CITY OF ALBUQUERQUE

February 13, 2018

RE: **Oso Bio Syringe Line**
Grading Plan for Building Permit 4401 Alexander Blvd
Engineer's Stamp Date 12/22/2017 Disapproved
Hydrology File: F16D003B1

TRAFFIC CIRCULATION PLAN

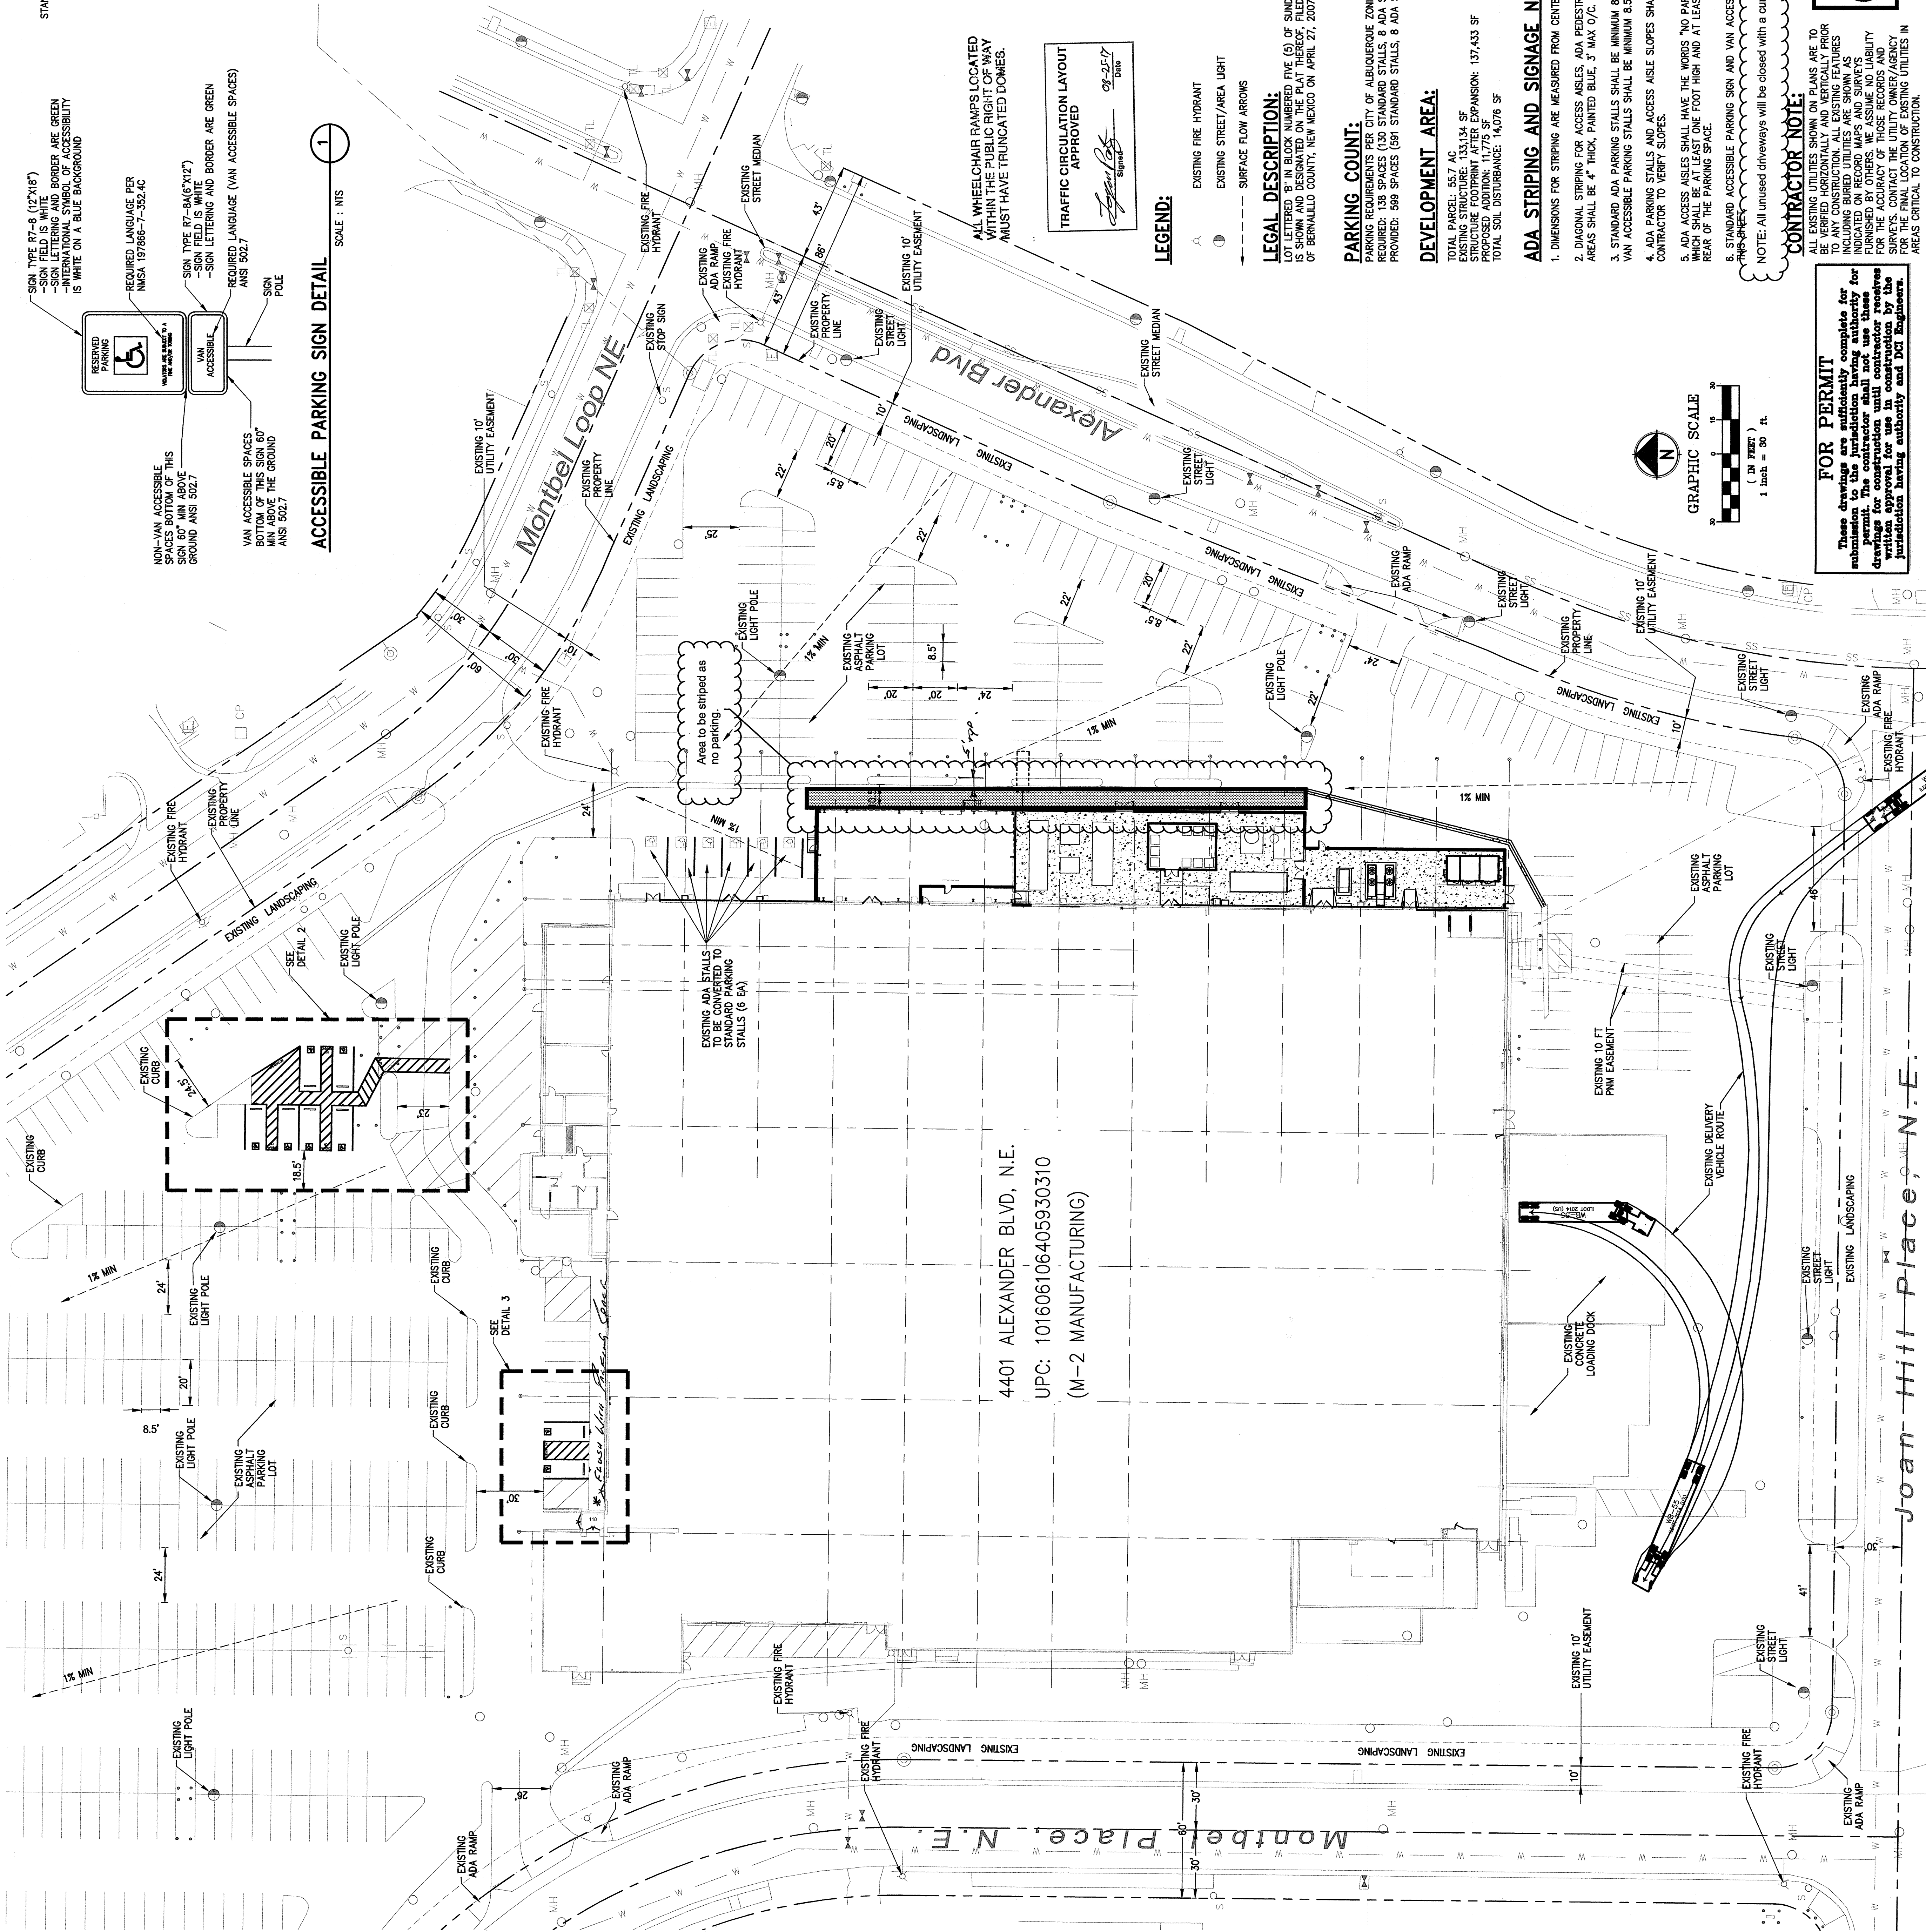
4. Sheet C 1.0 shows most of the driveways to be closed but one additional driveway on the north end of the site needs to be closed and must be shown on the plans. It shows up on sheet C1.3. Since pond reconstruction may impact the right of way, notes should be added to sheet C1.3 also, stating "An excavation permit will be required before beginning any work within City Right-Of-Way". Another note should state "Two working days prior to any excavation, the contractor must contact New Mexico One Call, dial "811" [or (505) 260-1990] for the location of existing utilities. Prior to construction, the contractor shall excavate and verify the locations of all obstructions. Should a conflict exist, the contractor shall notify the engineer so that the conflict can be resolved with a minimum amount of delay."
